Application No: EP/47/21/HH  
Site Address: West House South Strand East Preston BN16 1PN  
Description of works: Erection of second floor addition, part single storey side, part two storey front, side and rear extensions and alterations to fenestration/openings

Thank you for your internet representation made on 6th June 2021 which has been recorded as an objection with the comments as follows:

E ELEV

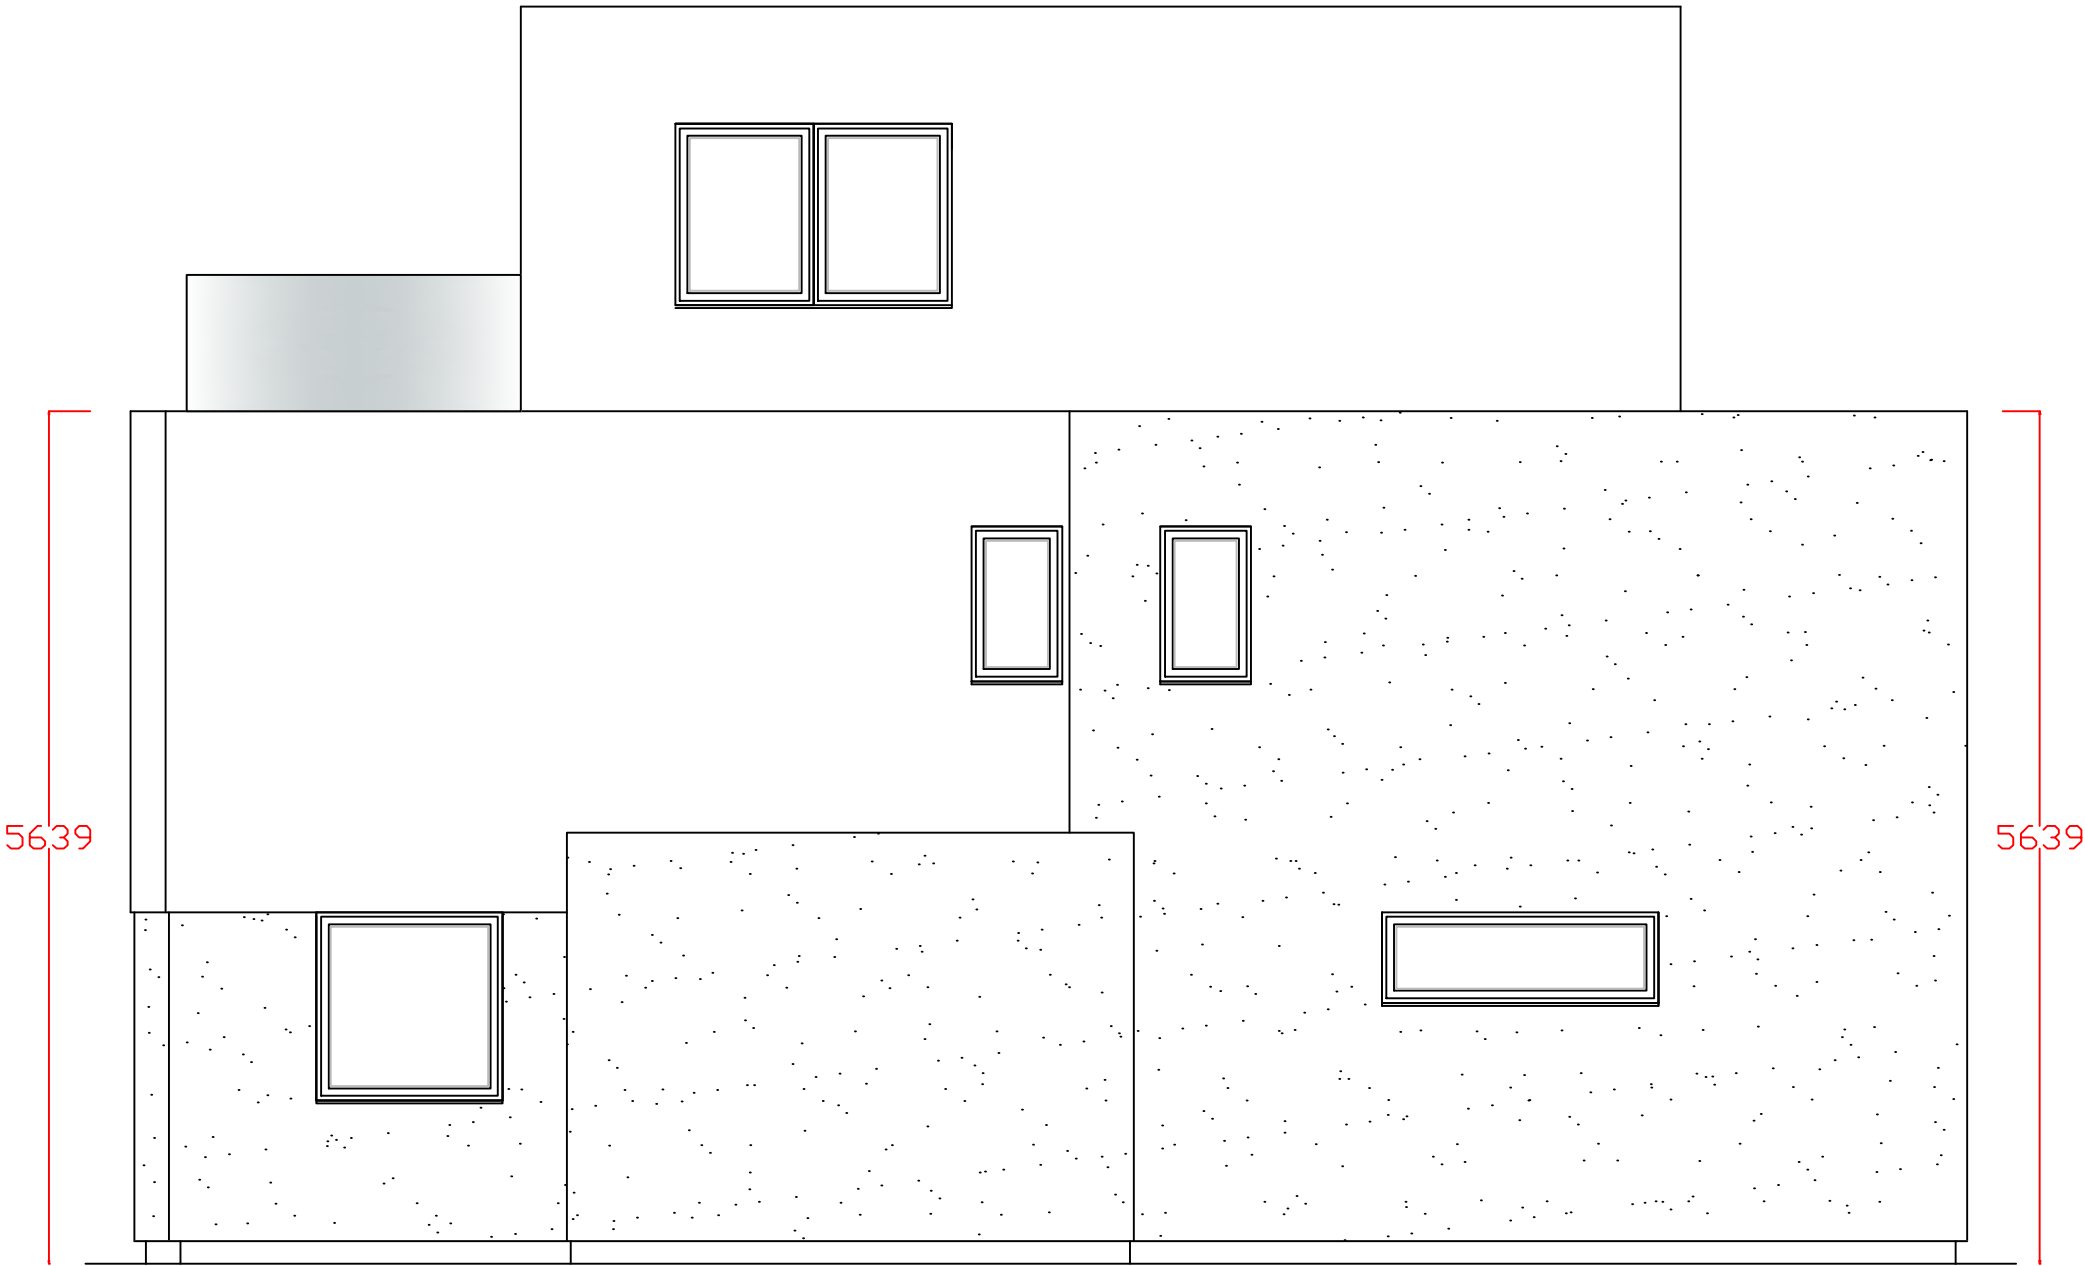
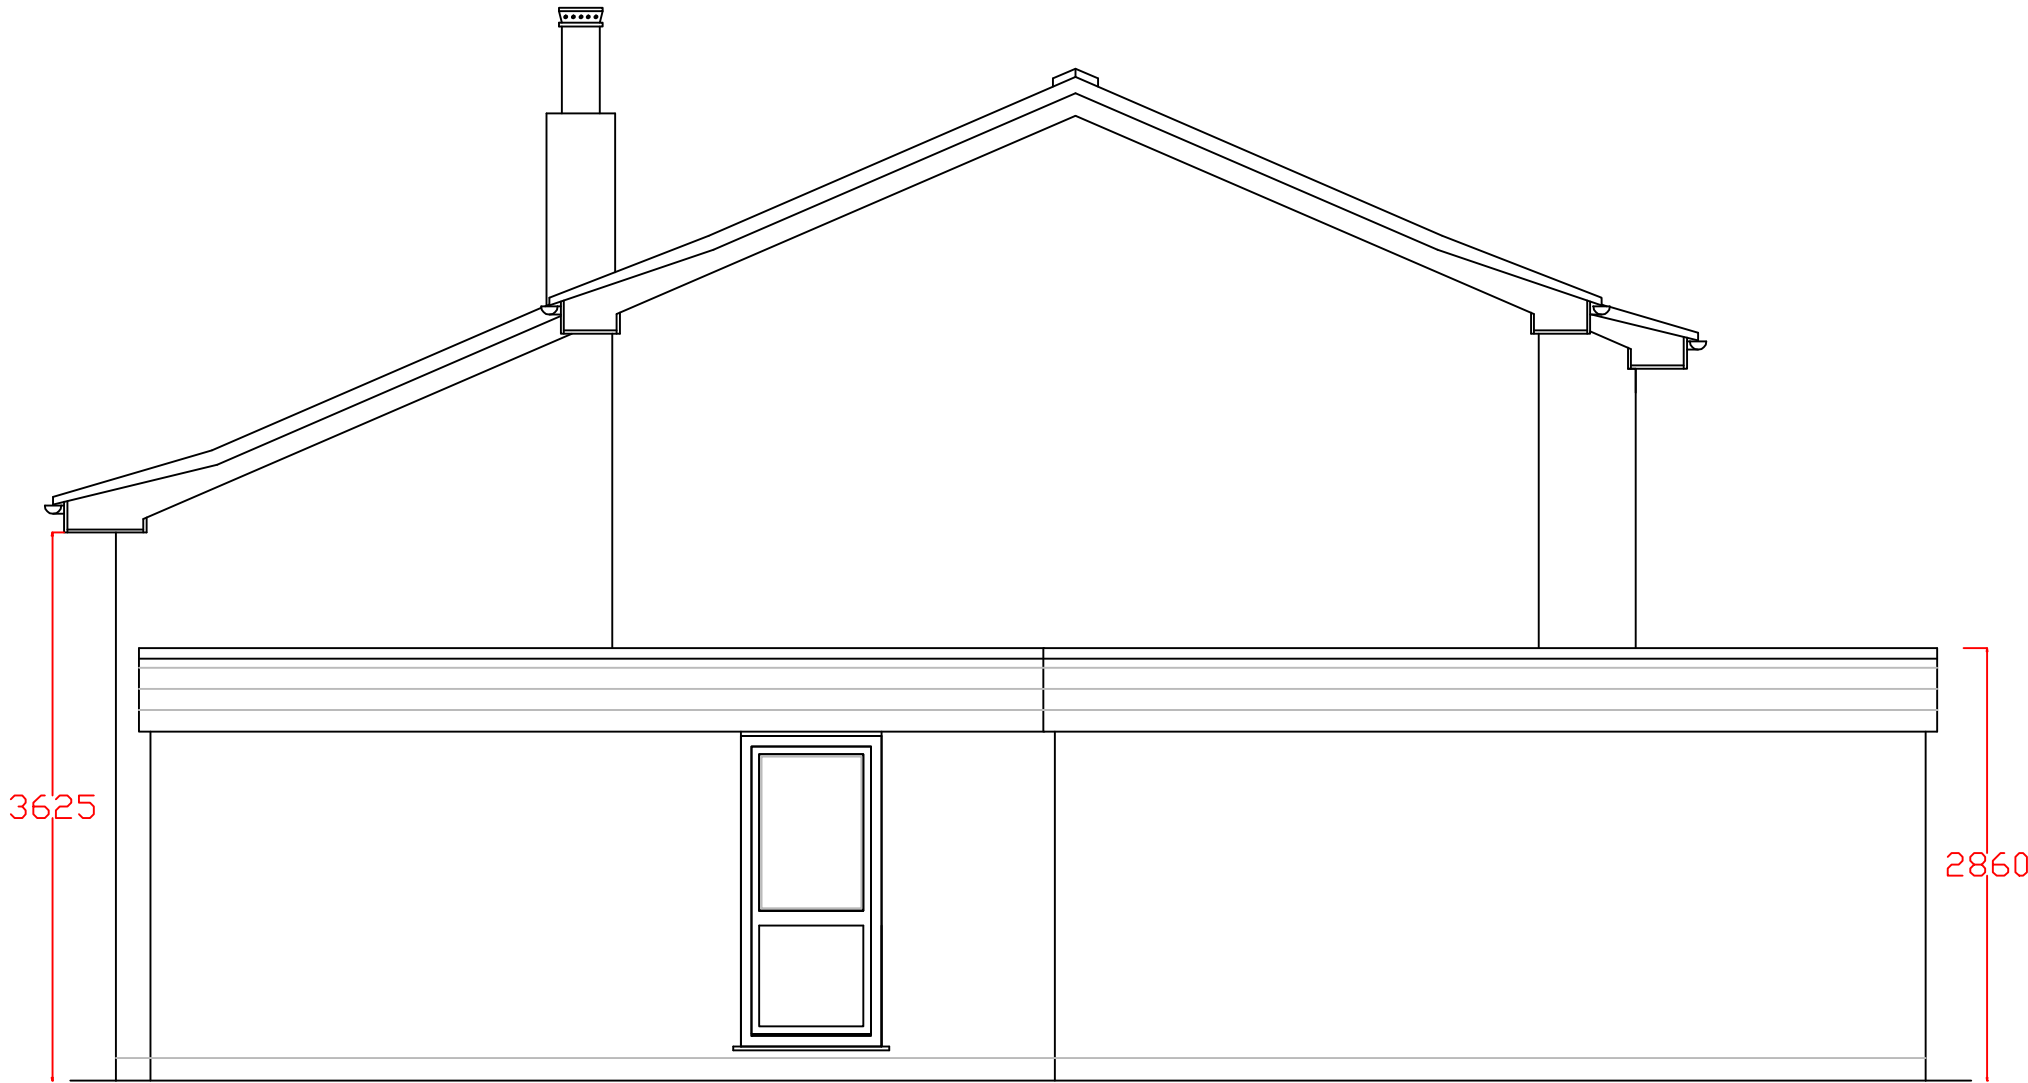
Our second concern is with regards to the second floor extension. We share the general concern already stated in previous correspondence that the second floor extension is not in keeping with the majority of residences along South Strand. However, our specific concern is the east facing window from the second floor sitting room window which will look directly onto our garden.
